Office of Environment & Heritage

RE: Cobbora Coal Project (10_0001) Exhibited Environmental Assessment

I refer to your letter received on 3 October 2012 seeking comment from the Office of Environment and Heritage on the exhibited Environmental Assessment (EA) for the Cobbora Coal Project.

Figure 3.14

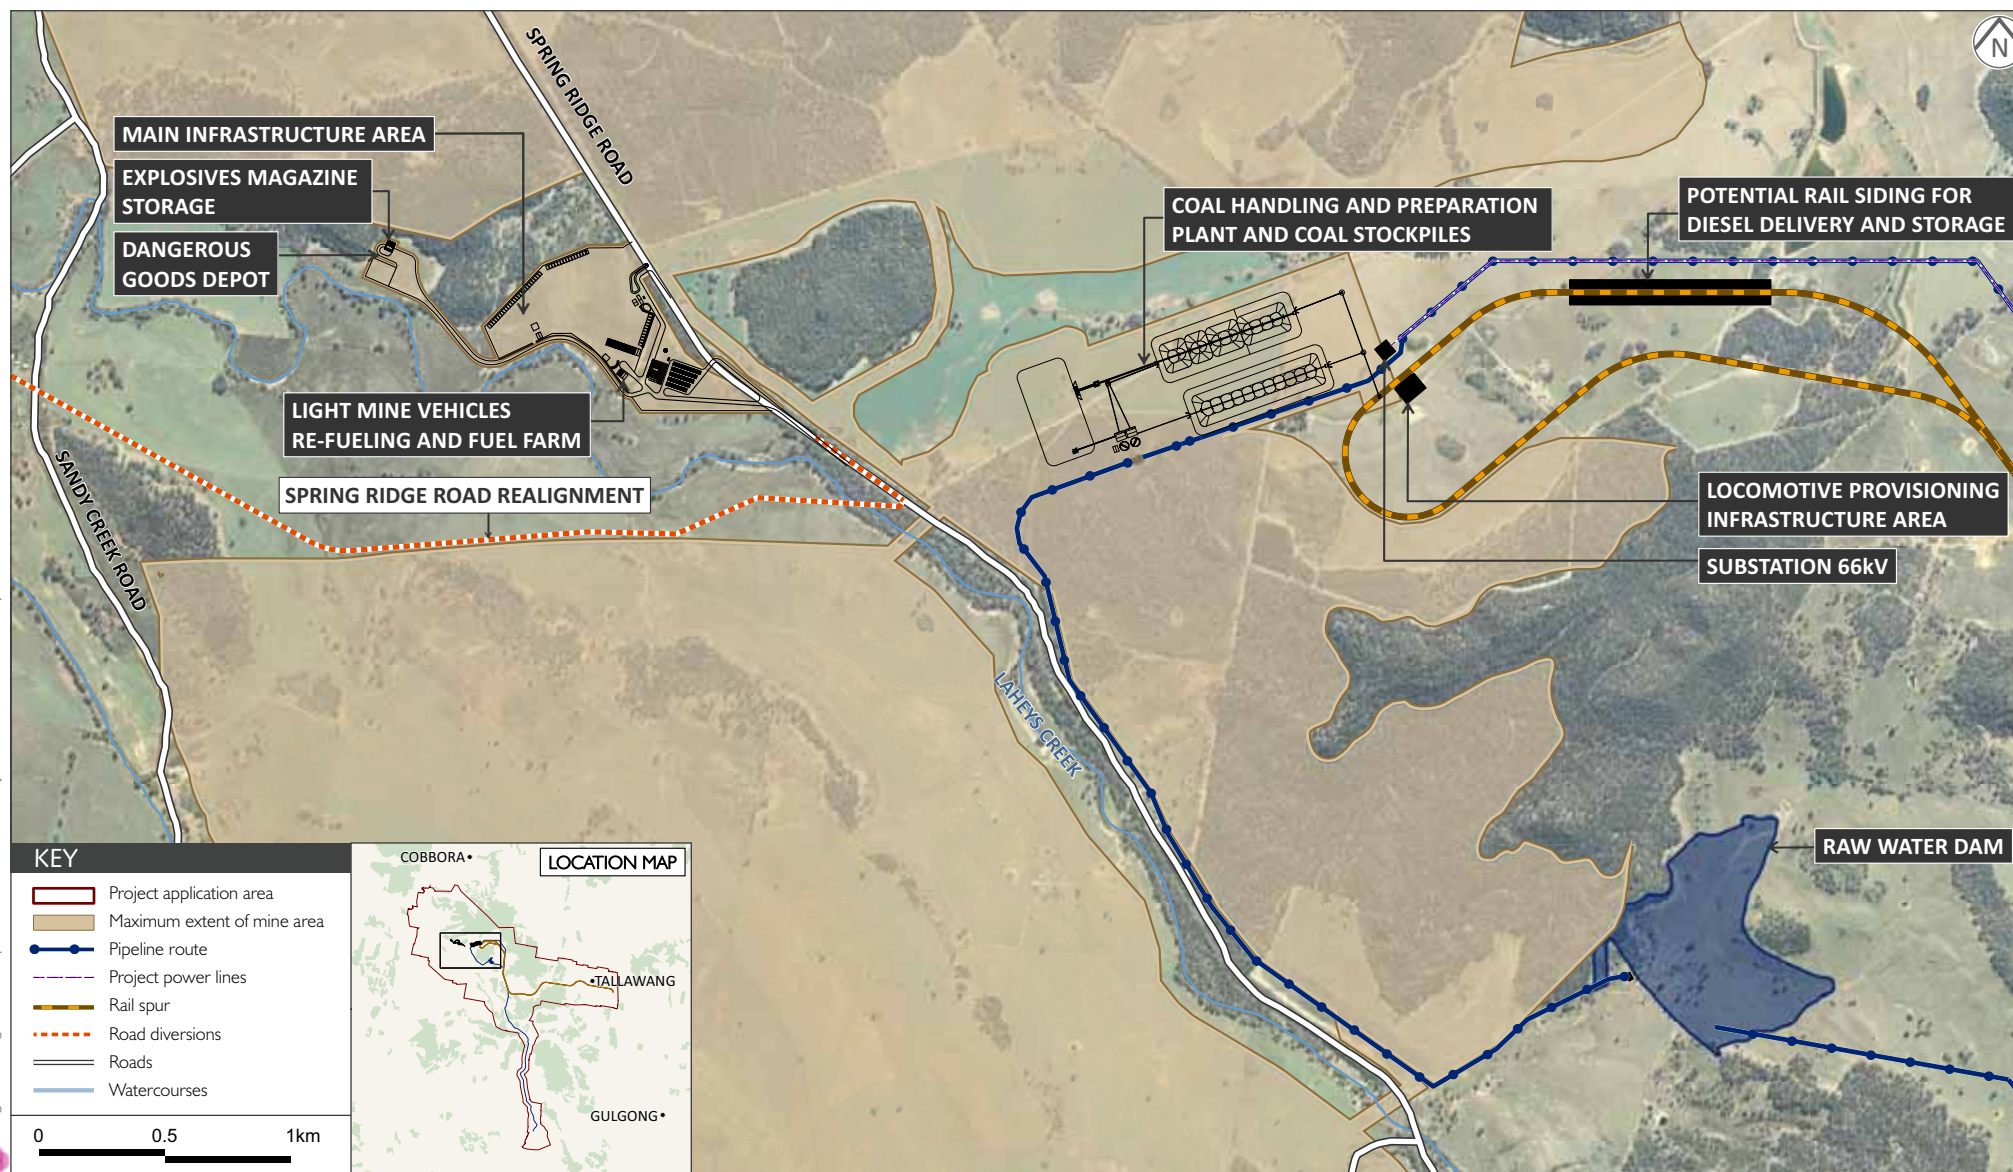
The EA also states that a small section of Brooklyn Road will be realigned to the north of the rail spur and a road underpass of the rail spur will provide access to the south. It is not clear where the underpass is proposed to be or whether this is to enable access to Goodman SCA. The location of the underpass needs to be indicated on Figure 3.14. The underpass must also be large enough to allow suitable access for heavy plant and vehicles such as graders on low loaders, heavy combination vehicles and Category 1 fire fighting tankers. A low level crossing would be preferable to an underpass to enable access for these types of vehicles.

- amend Figure 3.16 depicting the location of the proposed pipeline in relation to the Yarrobil NP;
- amend Figure 3.14 to indicate the location of the proposed underpass for access to Goodiman SCA and consider the suitability of the underpass for heavy plant and vehicles;
- include specific consideration of the likely indirect impacts of the proposal on OEH Estate, including noise, light spill, dust, and future fire management, and the likely level of mitigation expected to be achieved;
- consider the impacts of grass and bush fires and management strategies for the entire Project Application Area (PAA);
- demonstrate consideration of the RFS Bushfire Risk Management Plans for the relevant RFS Zones.
